Ribble Valley Borough Council

App no: 3.2026.0050

Address: Land adj Preston Road Ribchester PR3 3XL

Proposal: Permission in principle for erection of up to two dwellings.

Location Plan scale: 1/1250th

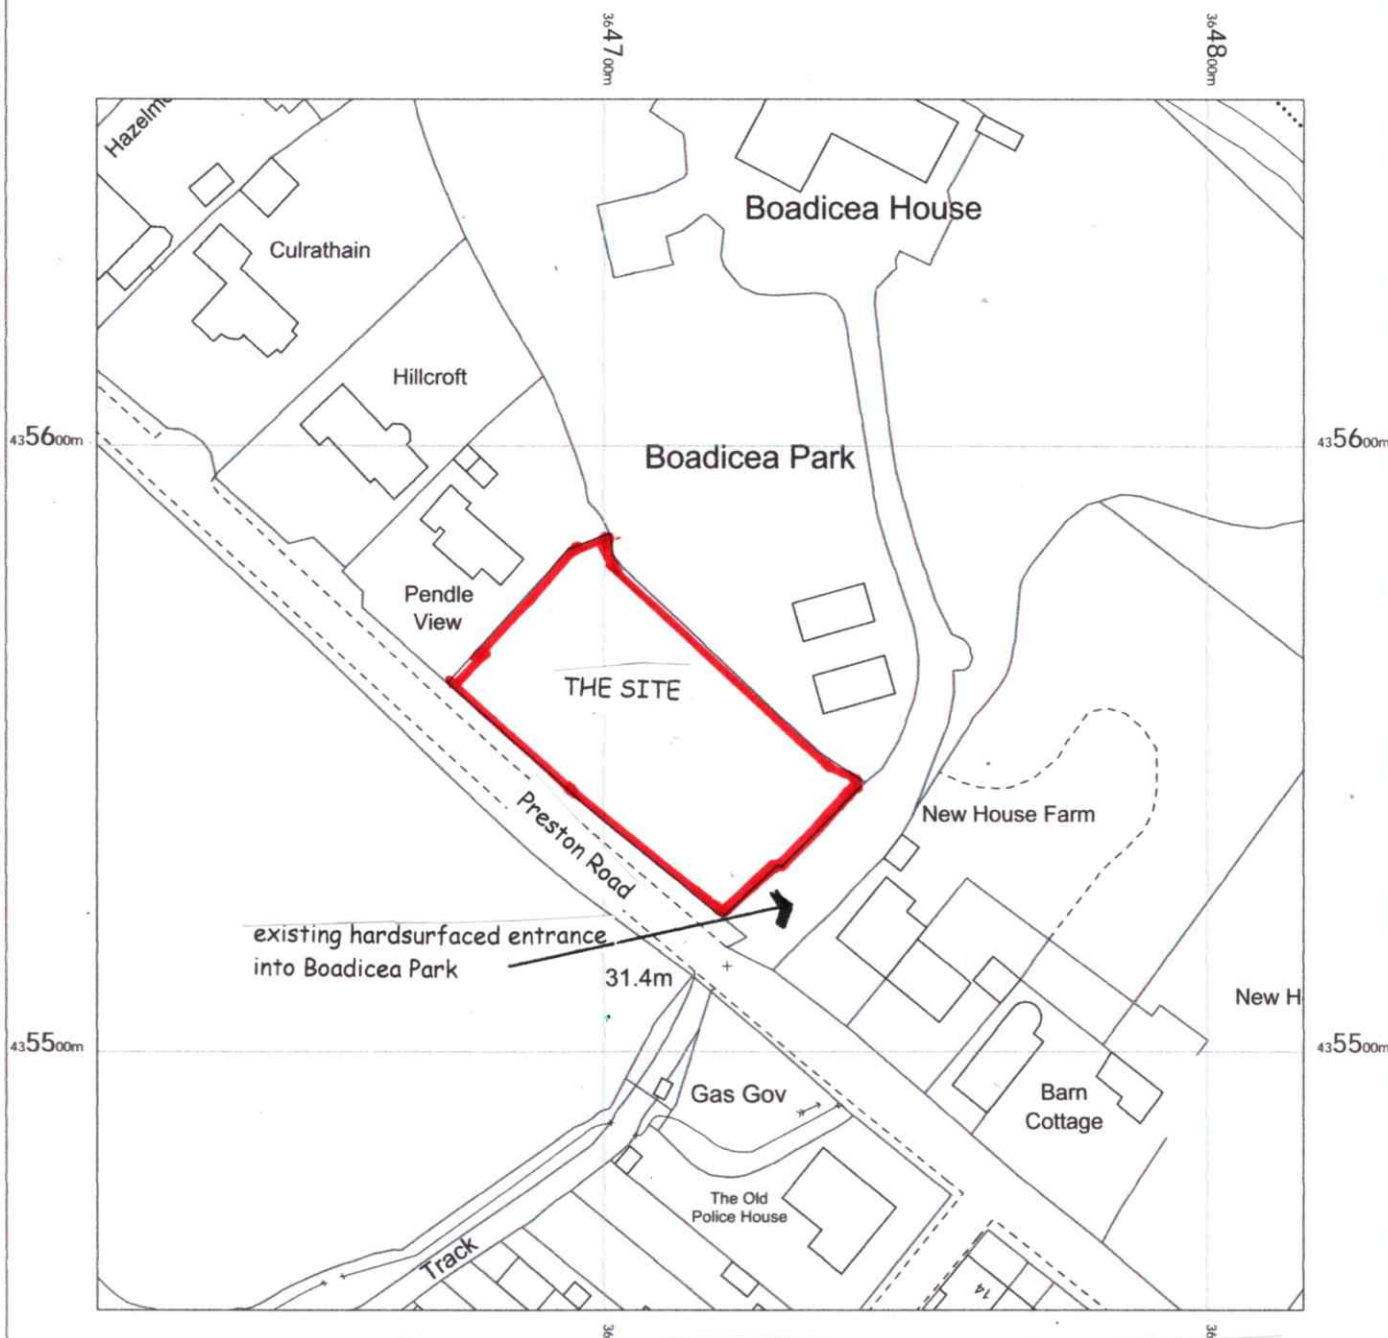
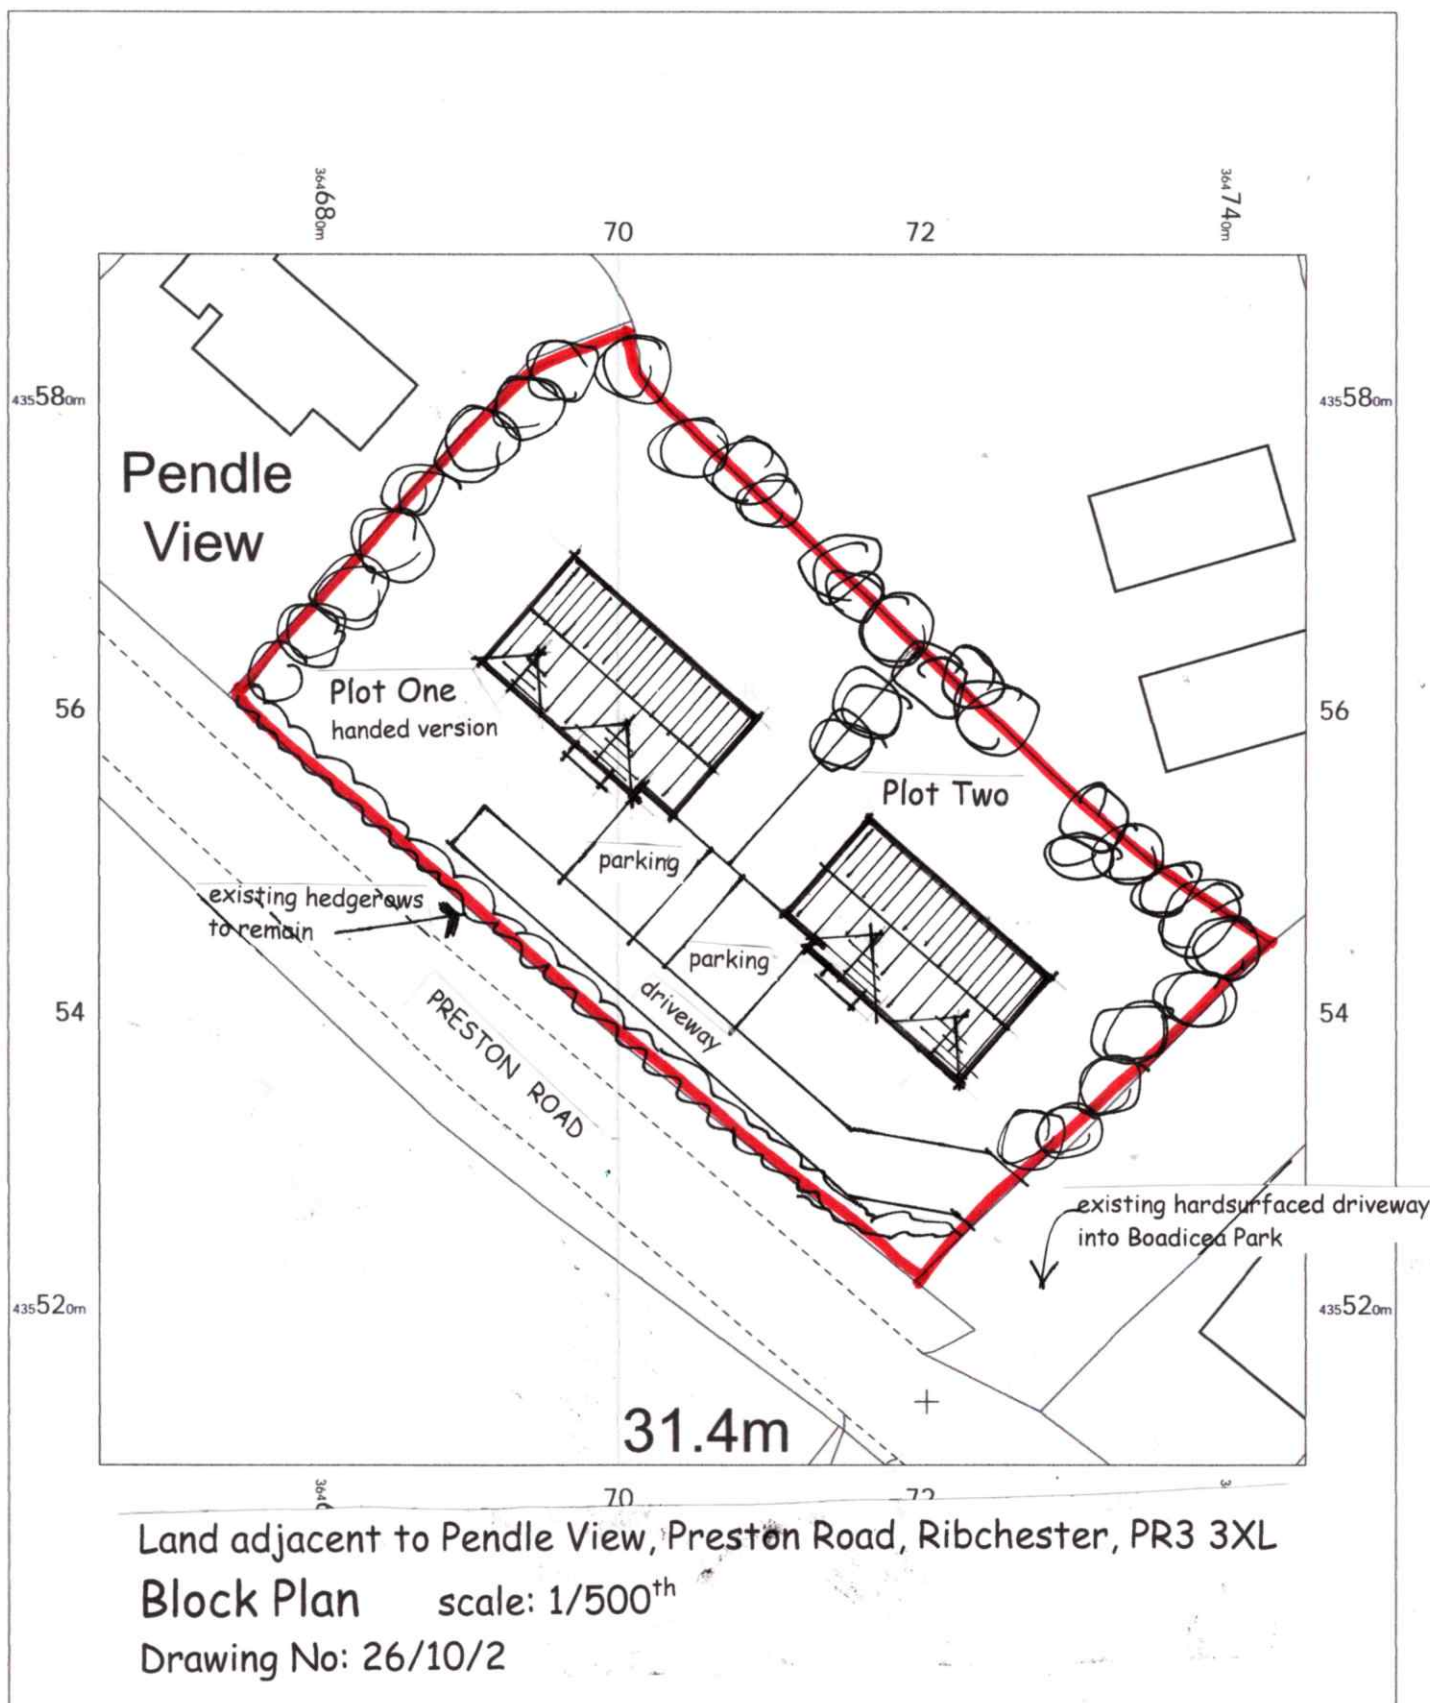
The site is proposed to be accessed from the adjacent access to Boadicea Park, the access is not in the red edge.

The site access to Boadicea Park is conditioned to be surfaced in a bound and porous material the first 10m under condition 5 of 3/2022/0530 and be 7m wide under condition 7 of the same permission. The visibility splays are X2.4m by Y25m to both sides along the nearside edge of Preston Road.

We would require this application to provide access improvements including measures for pedestrians to safely access the highway on a separate footway.

The provision of direct accesses from each dwelling onto Preston Road is not proposed however it would likely reduce vehicle speeds on Preston Road by the urbanisation of the street scene and the provision of a footway, in the highway verge and visibility splays to match those agreed at the Boadicia Park access. The reduction of vehicle speeds on Preston Road is supported by the Highway Authority.
